Your Ref: DA MP 08-0096  
S08/0028  
Our Ref: G08/1690  
DA08053051431 MH

Date: 02-Jun-2008

**RE: Land Use Application for BAYSWOOD RETIREMENT VILLAGE, BAYSWOOD NSW**

Figure 9 – APZ and dwellings subject to performance criteria

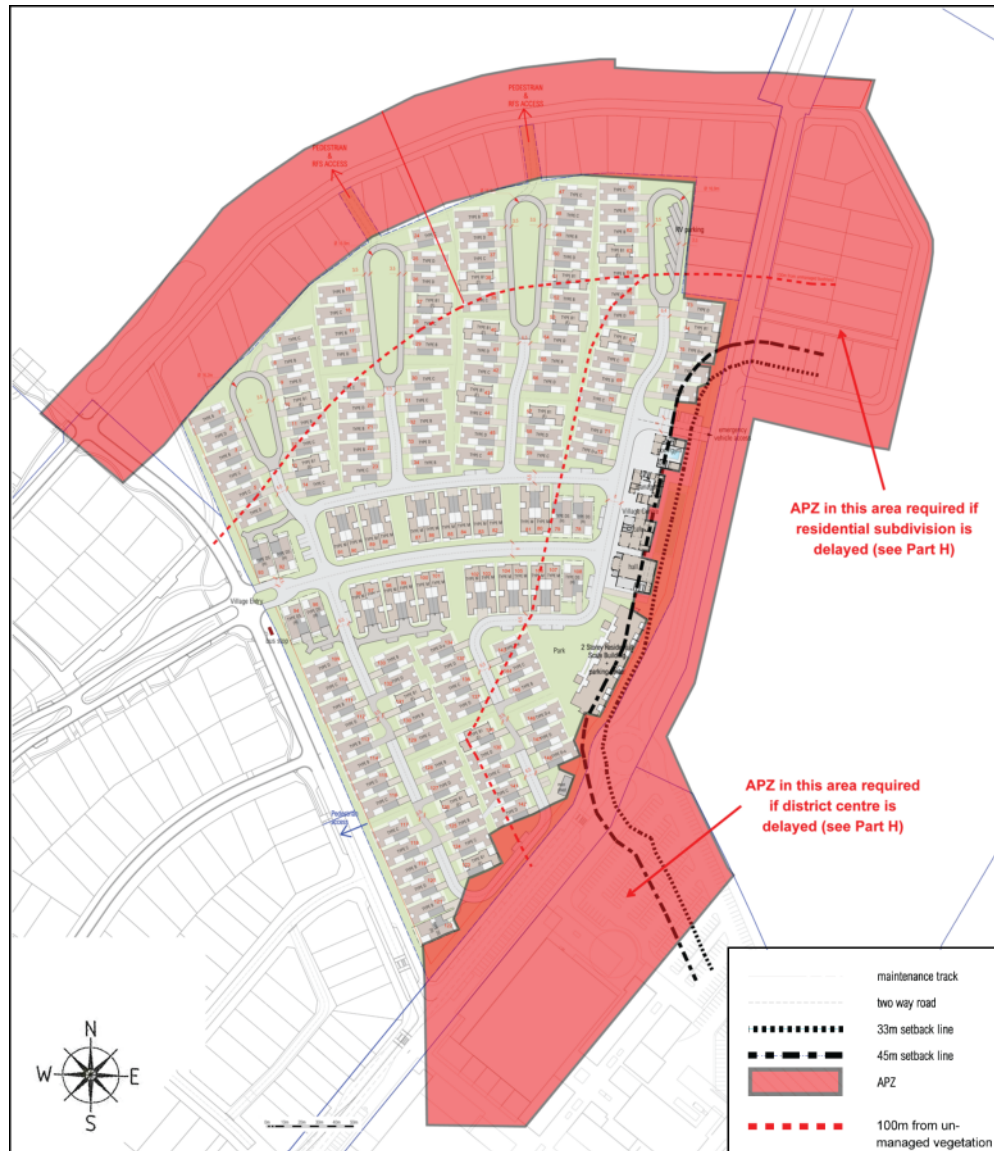
1. The proposal to reduce the flame width within the bushfire attack assessment calculations has been modelled on the slope and vegetation classifications supplied by the consultant. The modelling results indicate a radiant heat load of  $>10\text{kW/m}^2$  will impact the proposed development. The applicant is requested to submit further details demonstrating how the appropriate asset protection zone of 45 metres, as indicated by the asset protection zone modelling report in Appendix 1 of the Bushfire Report by BES (Ref:B1080021, May 2008) can be achieved within the proposed subdivision.
